PORTLAND MAINE

April 23rd, 2013

Project Name: **Riverside Golf Course Pro Shop, amendment to approved site plan #2012-432**
Project ID: #2013-090
Address: 1158 Riverside Street (in UI and e-plan as 910 Riverside Street)
CBL: 357-A-1
Applicant: Portland Department of Recreation and Facilities Management
Planner: Jean Fraser

**PROPOSED RIVERSIDE SOUTH GOLF COURSE
PRO SHOP & PARKING LOT STRIPING**

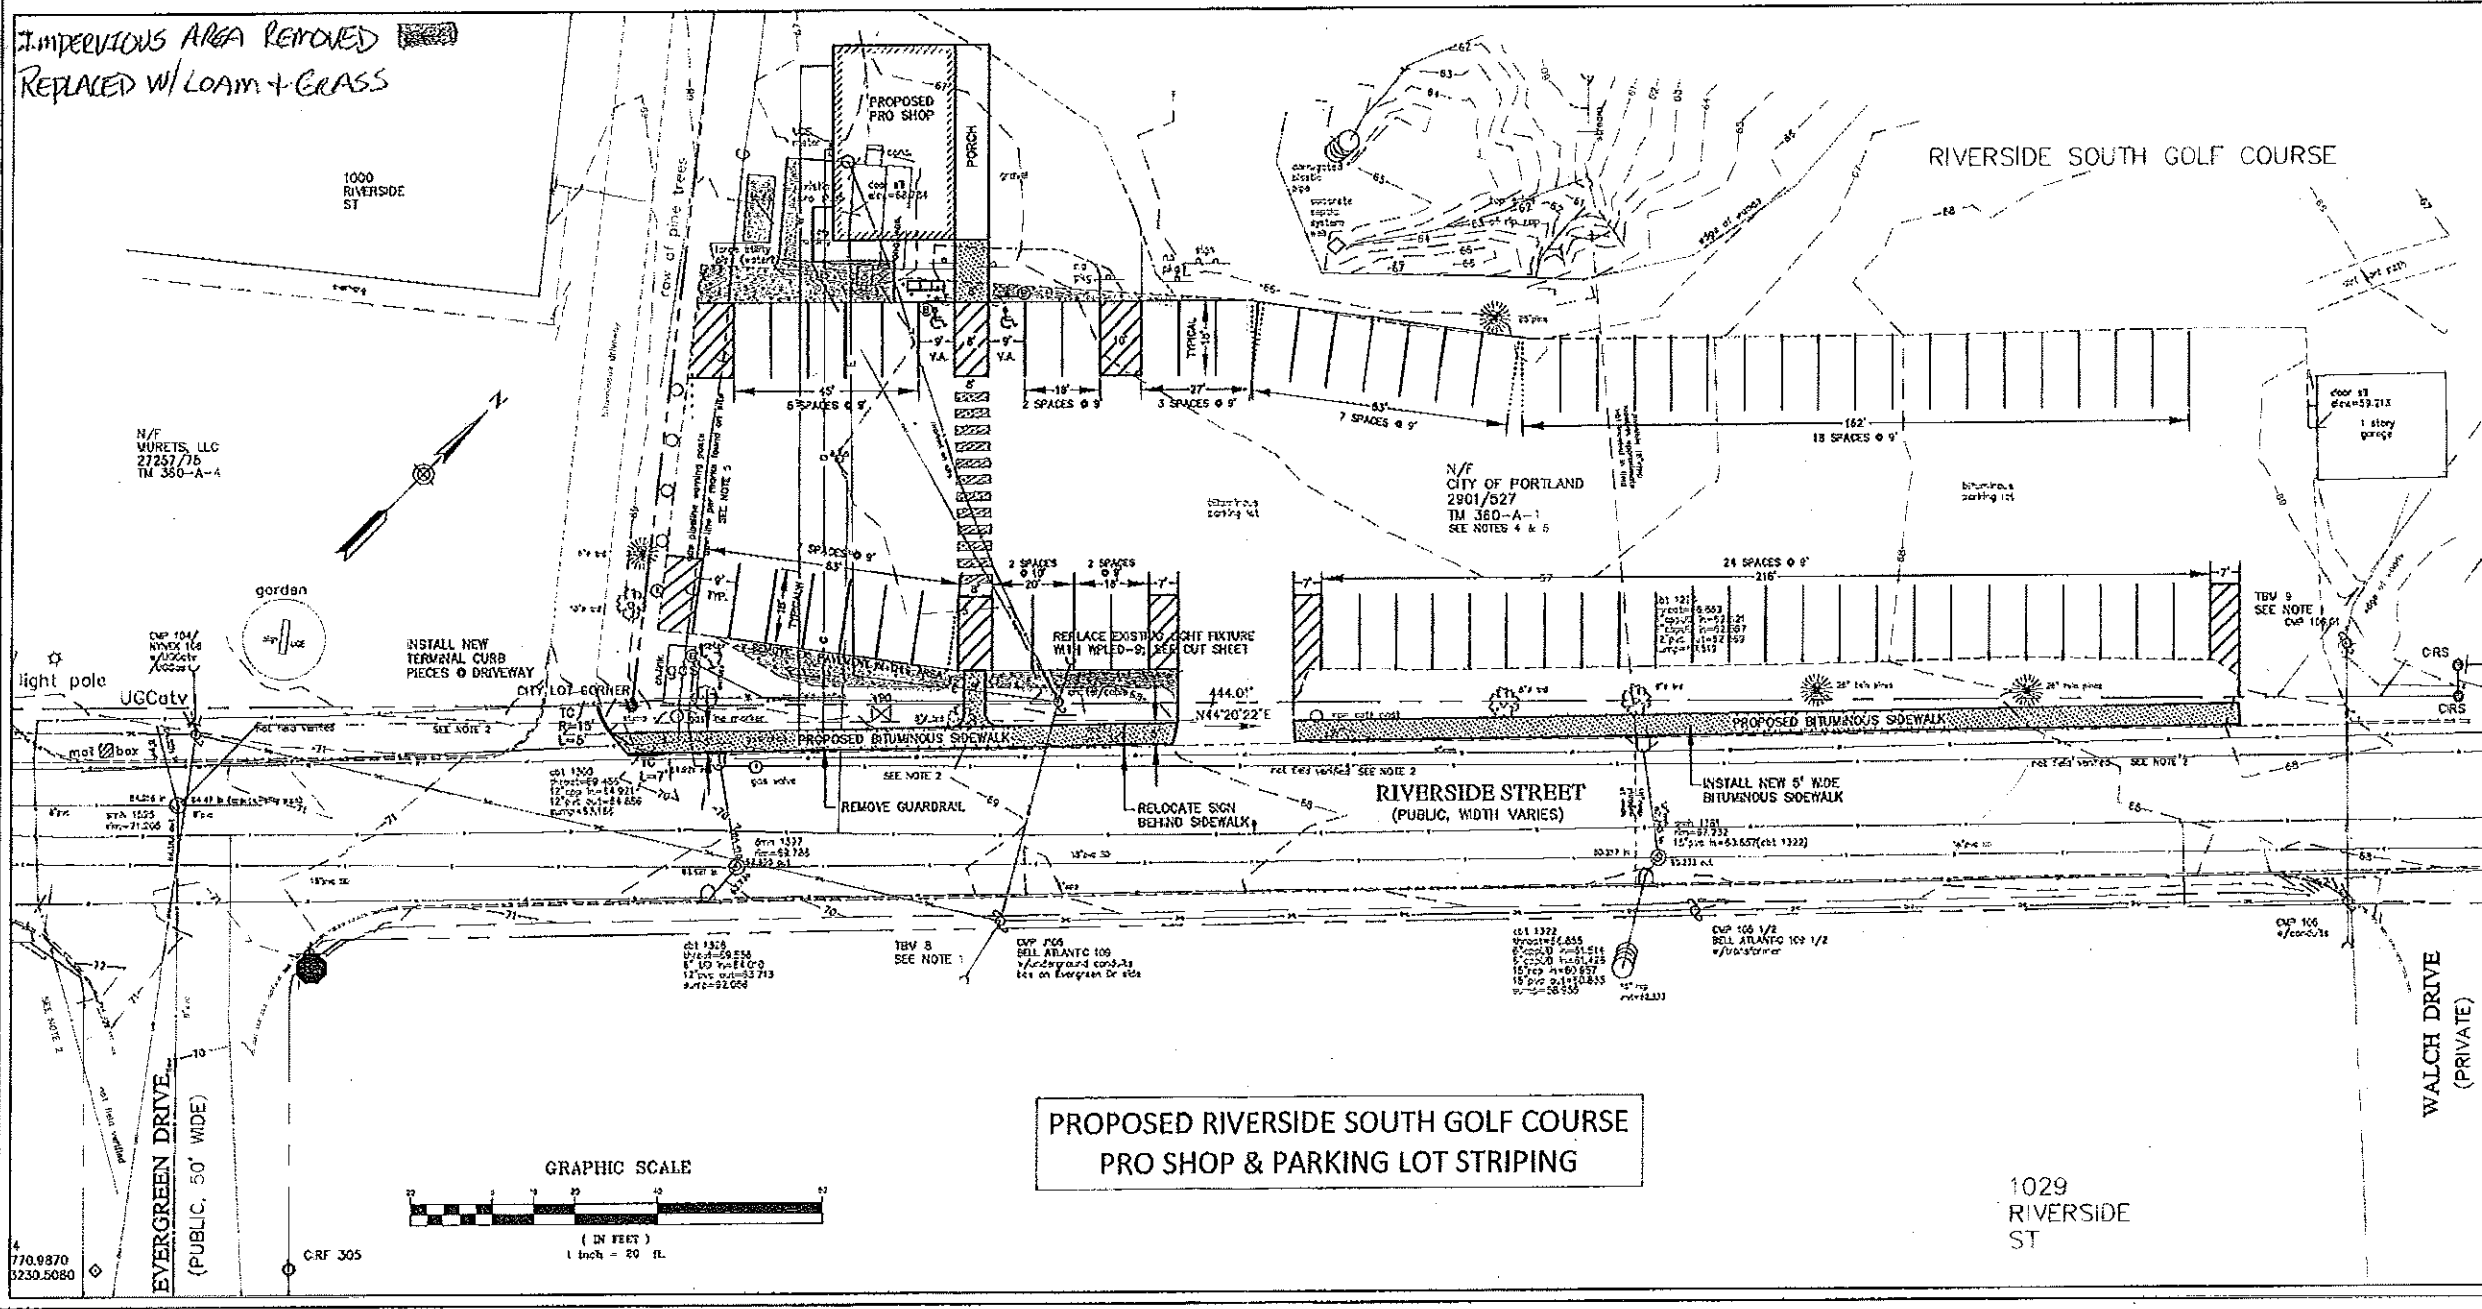
3. That the two 10' x 20' parking spaces near the crosswalk shall be revised to meet City standards and the extra width be allocated to the painted end island at the driveway entrance (it will expand from 7 feet to 9 feet); and

7. That the applicant is advised (but not required) to install pavement markings to discourage parking where the cart path enters the parking lot (for end of parking lot) to ensure that the path is not blocked by parked vehicles; and
